From: Hutchinson, William [<mailto:William.Hutchinson@naturalengland.org.uk>]
Sent: 01 March 2019 11:18
To: Wilson, Jennifer <jennifer.wilson@environment-agency.gov.uk>; Humpheryes, Ian <ian.humpheryes@environment-agency.gov.uk>
Cc: Relf, Christina <Christina.Relf@naturalengland.org.uk>
Subject: NE Saltmarsh Mitigation Plan Comments

Saltmarsh Mitigation, Reinstatement and Monitoring Plan – Revision B

Figure 2.4
Maximum area of disturbance within the Sandwich Bay to Hacklinge Marshes SSSI.

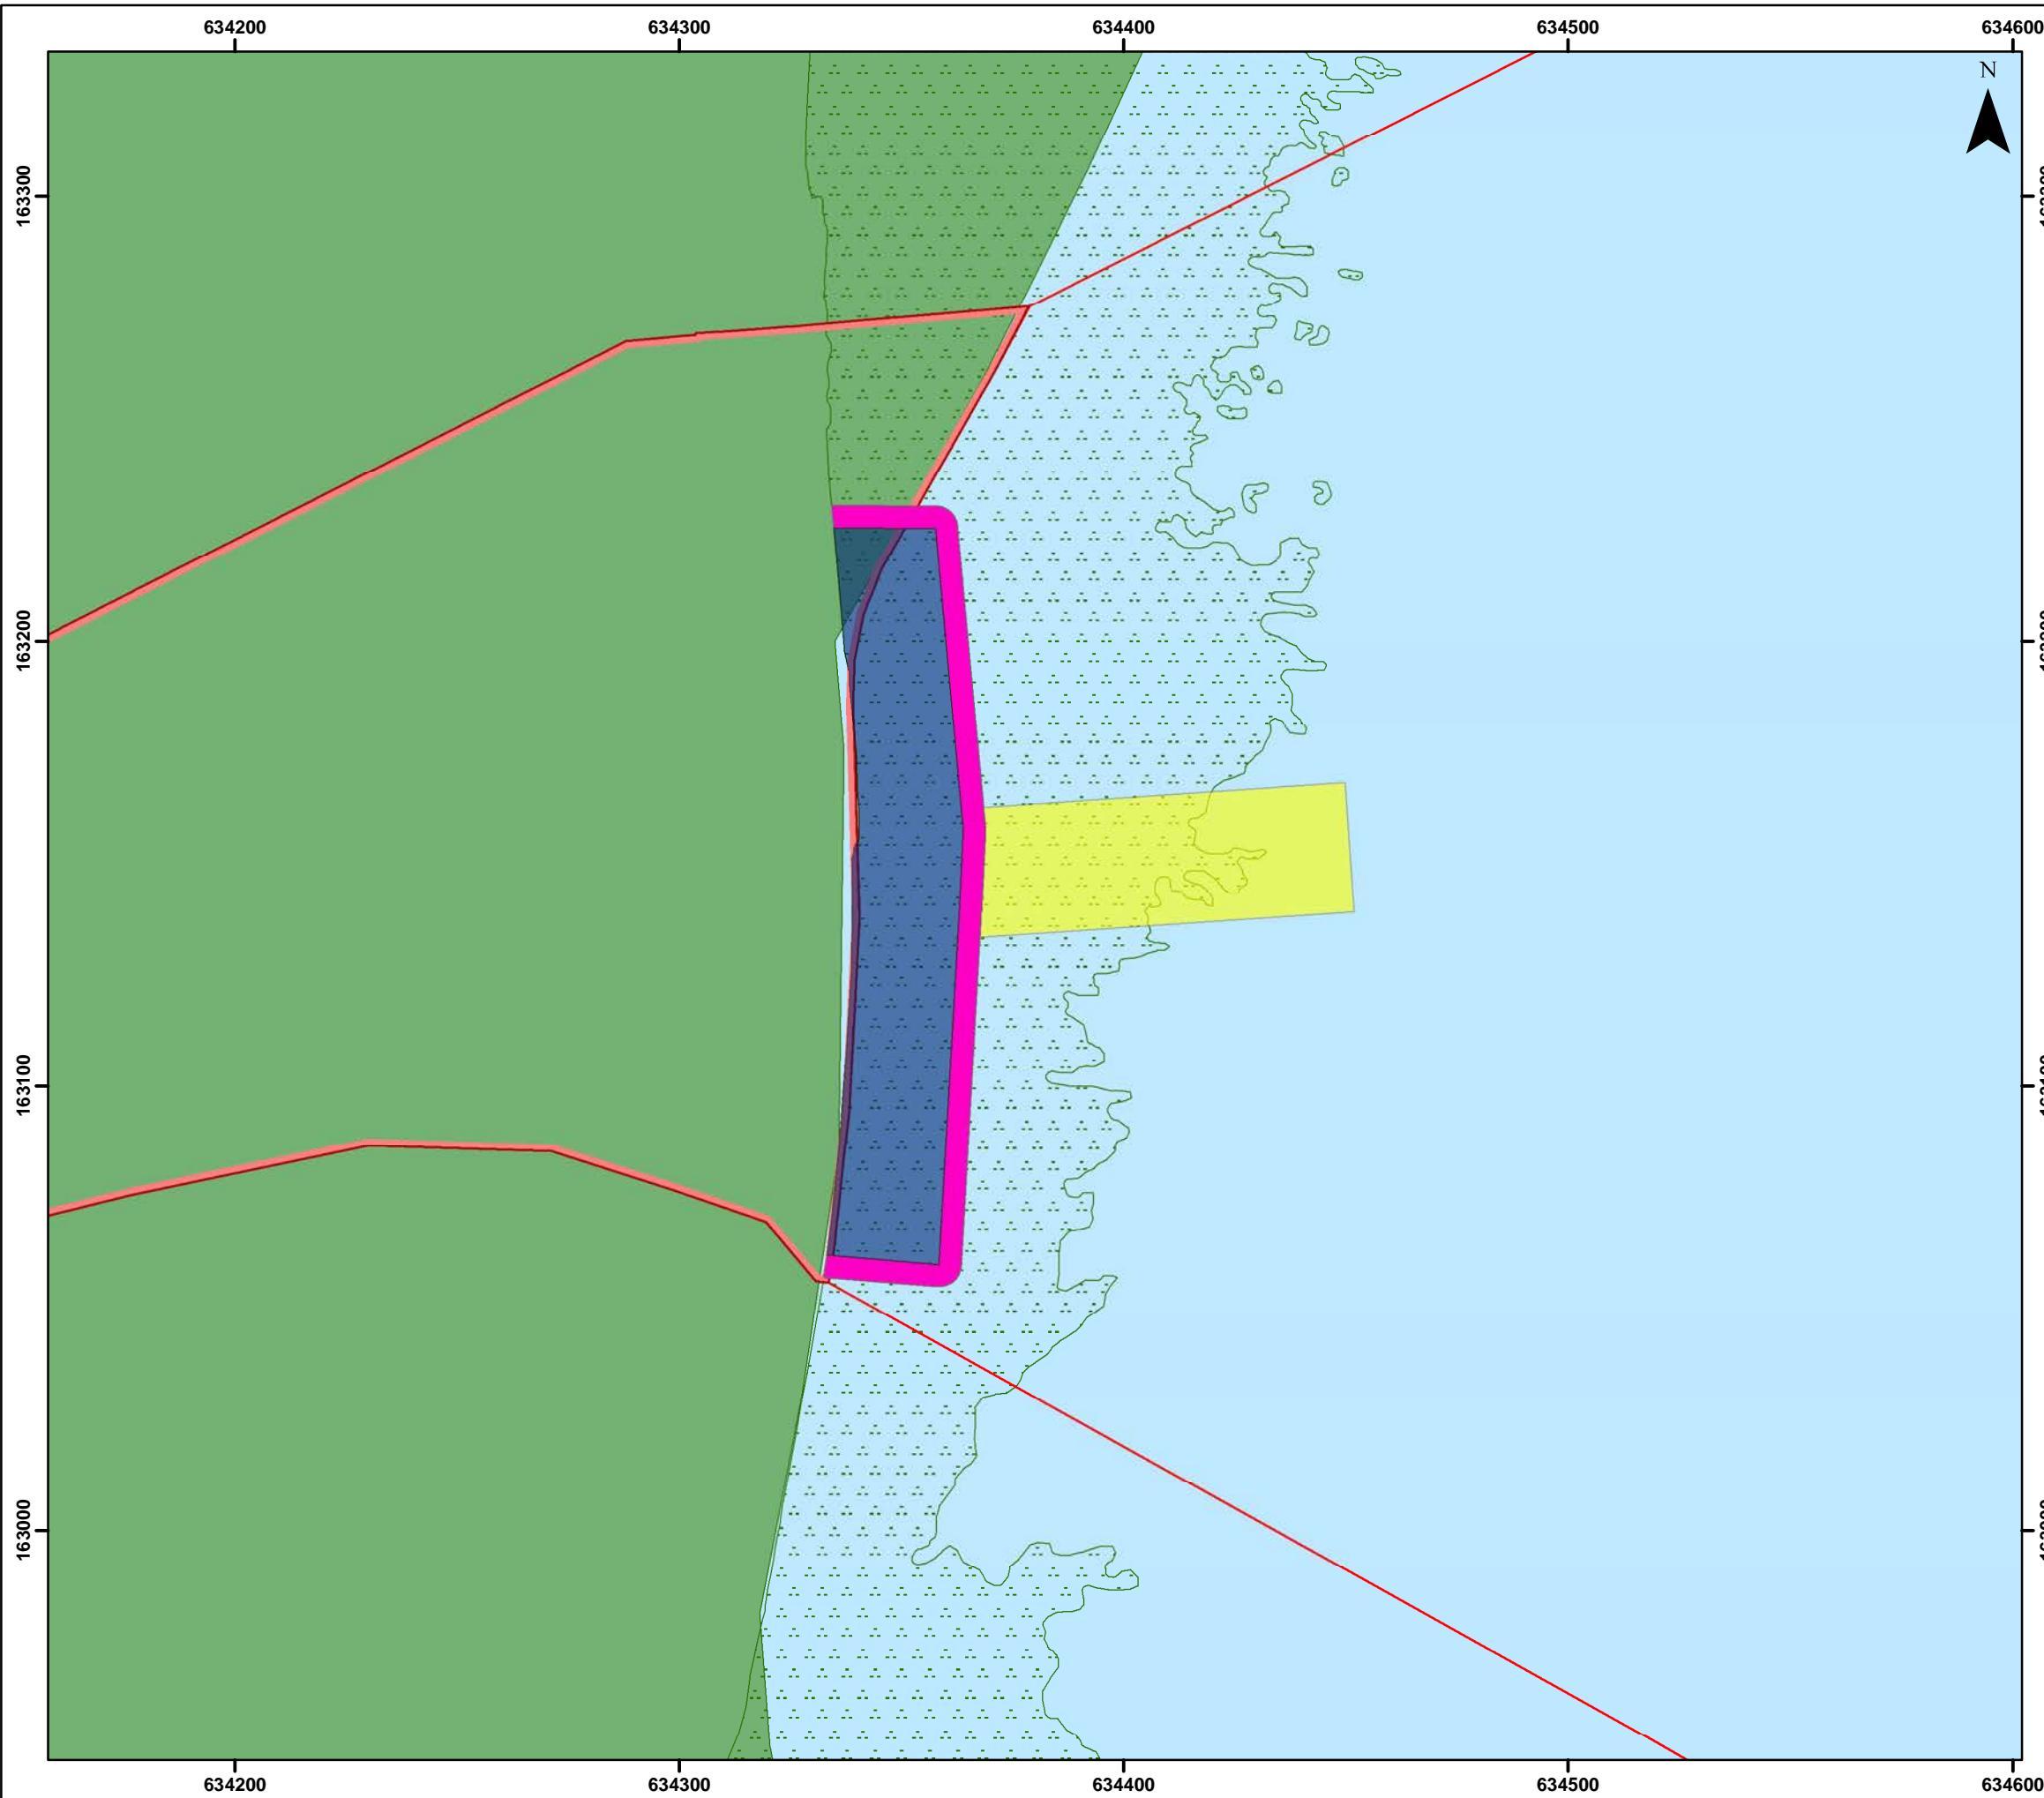
Point	Section	Comment
	Figure 2-4.	Will the whole 5m separation distance be used by transiting vehicles, and thus be disturbed? Alternatively, will a suitable track be laid within that 5m area?
